From: Vic Bray [REDACTED]
Sent: 09 August 2018 12:06
To: Amber Willard
Subject: Planning application 2, Ocean Drive Ferring FG/116/18/HH

I wish to comment and OPPOSE the proposed “Loft Extension “ at 2 Ocean Drive Ferring.

PROPOSED SOUTH WEST ELEVATION

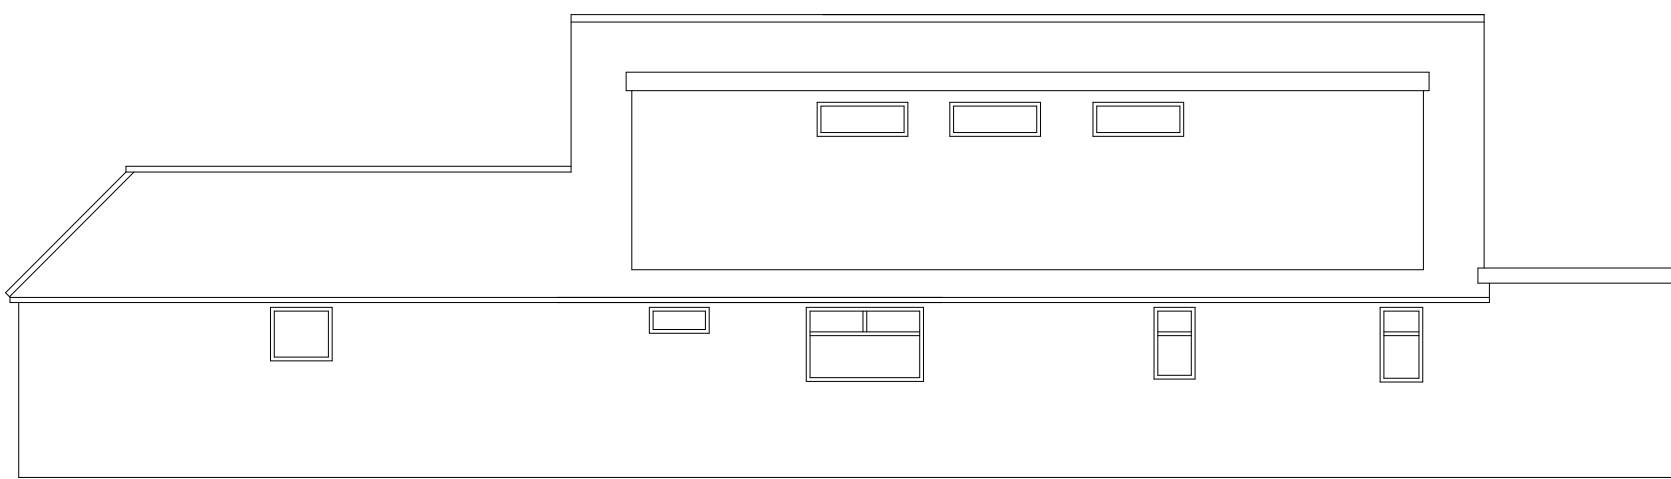
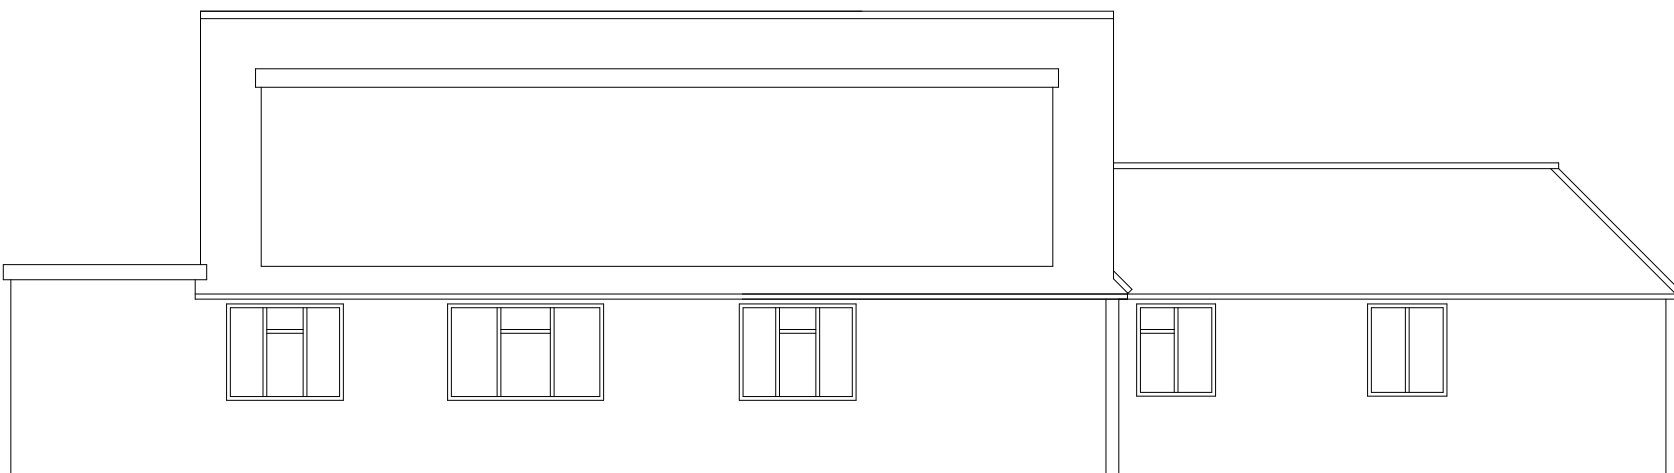
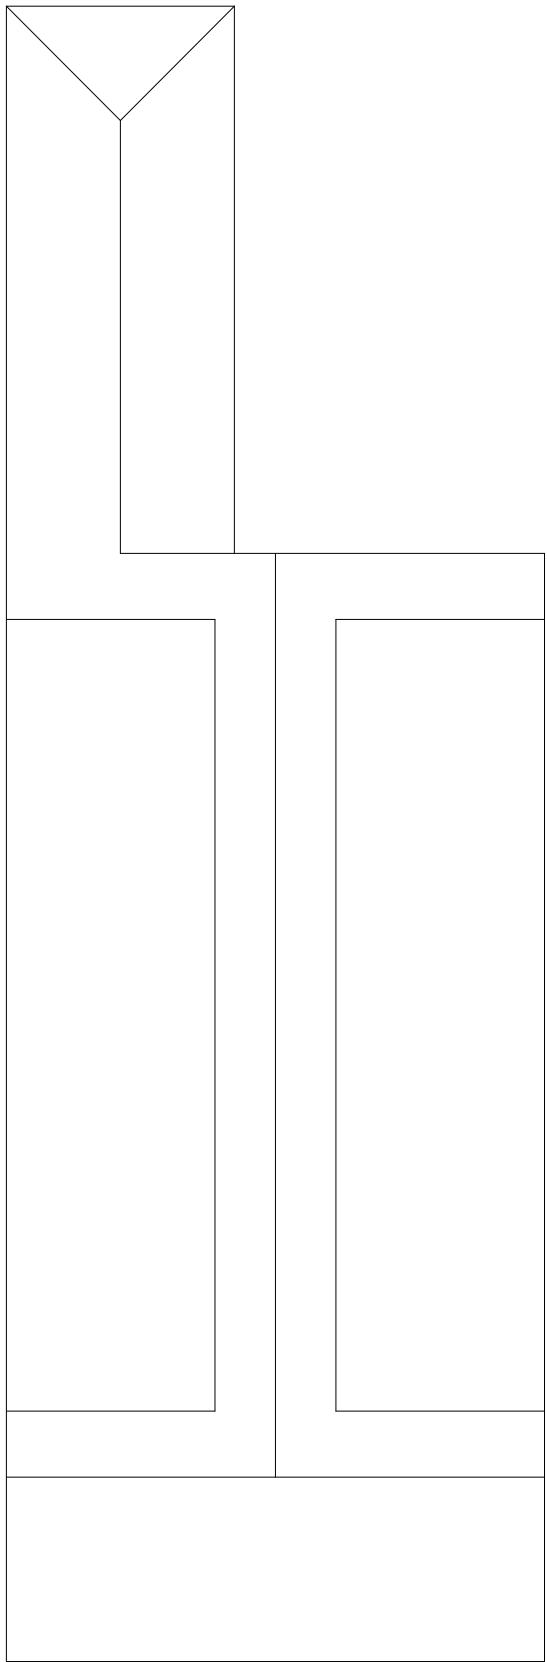
1. The application describes it as a “Loft Conversion” . It is hideously large, completely changes and ignores the characteristics of the existing property. This is not a loft conversion, but an attempt to build the largest property possible without regard to the size of plot. The proposed “Box” could have been drawn by a small child.

2 The design !! if it can be called that, is an aesthetic disaster that completely ignores the characteristics of the existing property , its relation to its neighbour No4 , that was built as a pair of pretty properties. both of which are on very narrow plots with little gap between them.

3 The plan, also appears to ignore overlooking windows on both sides and greatly reduces light and privacy currently enjoyed by neighbouring properties.
